### **Monument Glamping II, AL-23-18**

Please accept the following comments from El Paso County Public Health (EPCPH) regarding the proposed 5.95-acre lot special use referenced above:

SITE PLAN

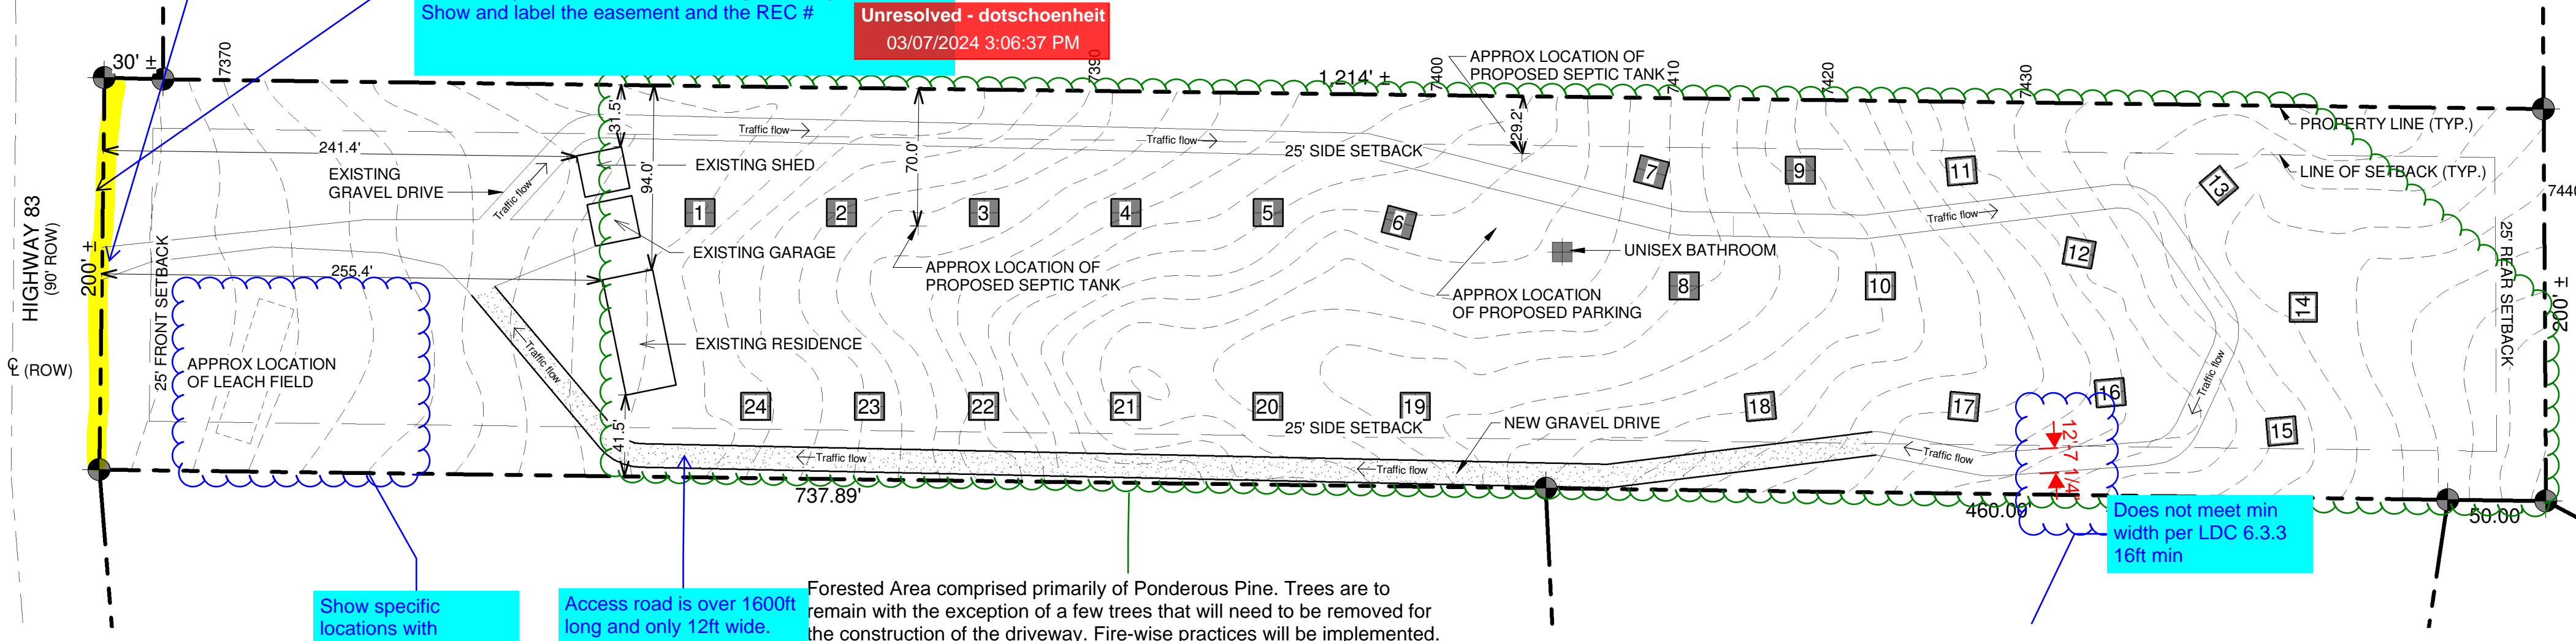
- Ardent Engineering Ltd. has submitted an onsite wastewater treatment system (OWTS) design for the 12 premium sites only; however, the Site Plan submitted shows 24 sites with no explanation of what the water or wastewater needs of the other 12 sites might be. Also, a unisex bathroom between sites 6 and 8 is noted on the Site Plan without any other design details on the planned use of this bathroom. The design submitted did not account for this bathroom. Compliance with all aspects of the EPCPH Onsite Wastewater Treatment System Regulations is required.
